# CITY OF ALBUQUERQUE

April 9, 2009

**Re: COA SW Mesa Park & Ride, Drainage Management Plan**  
**Engineer's Stamp dated -no stamp- (K10/D053)**

Based upon the information provided in your submittal received 4-3-09, the above referenced plan is approved for Site Development Plan for Building Permit action by the DRB.

## SOUTHWEST MESA PARK & RIDE DRAINAGE MANAGEMENT PLAN

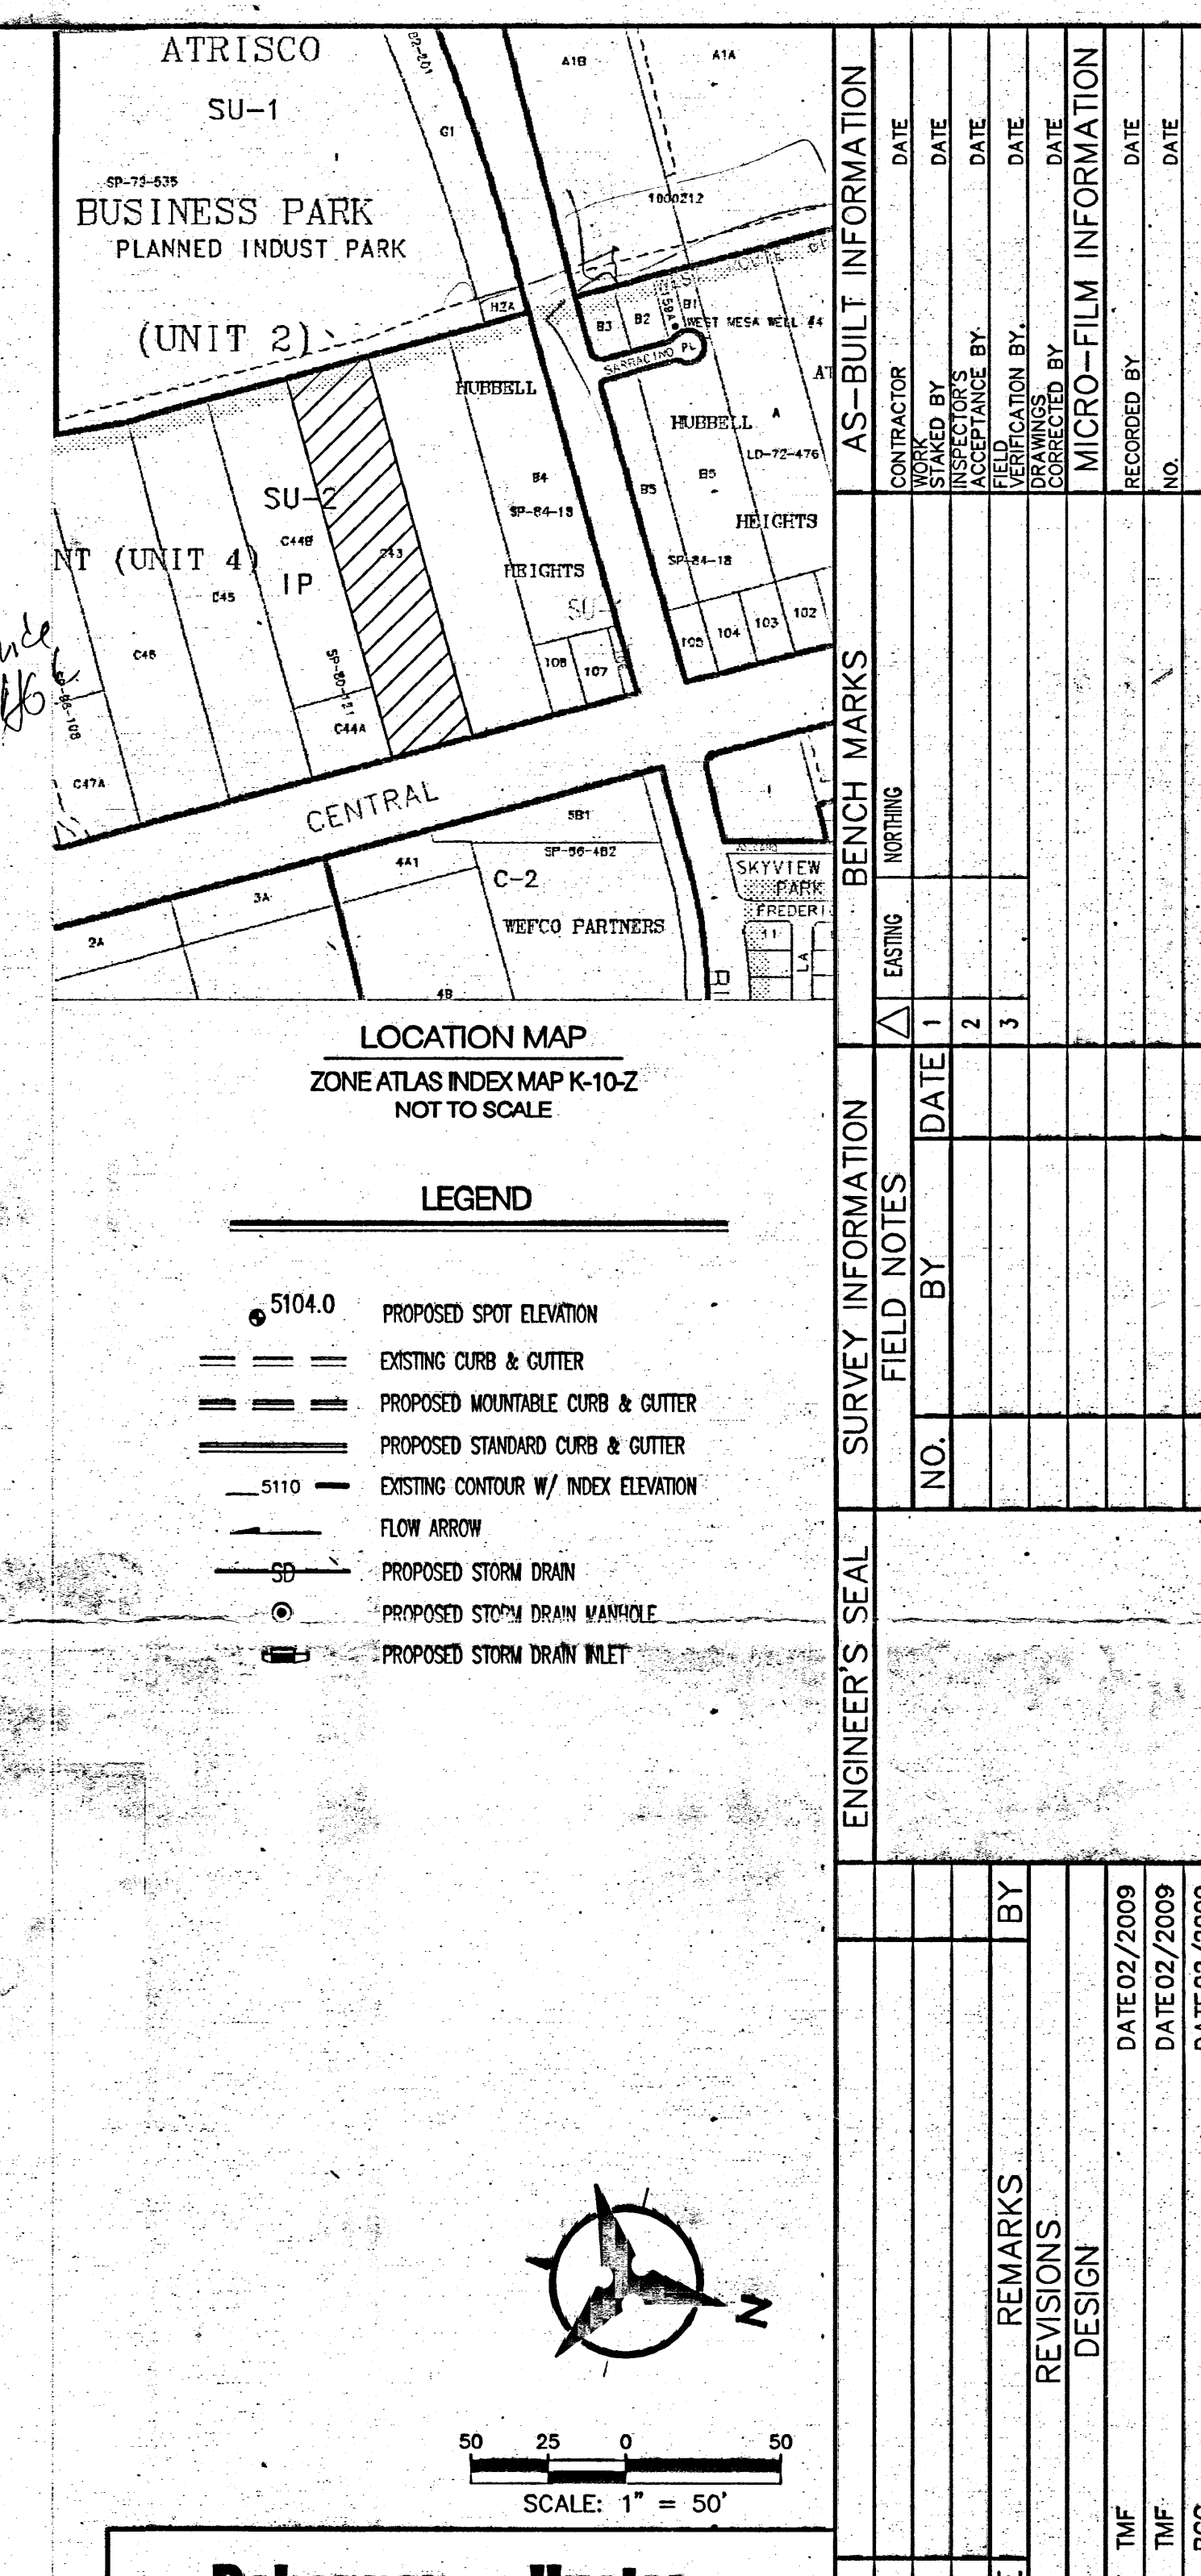
When submitting for Building Permit, provide the HGL in the storm drain this site ties into.
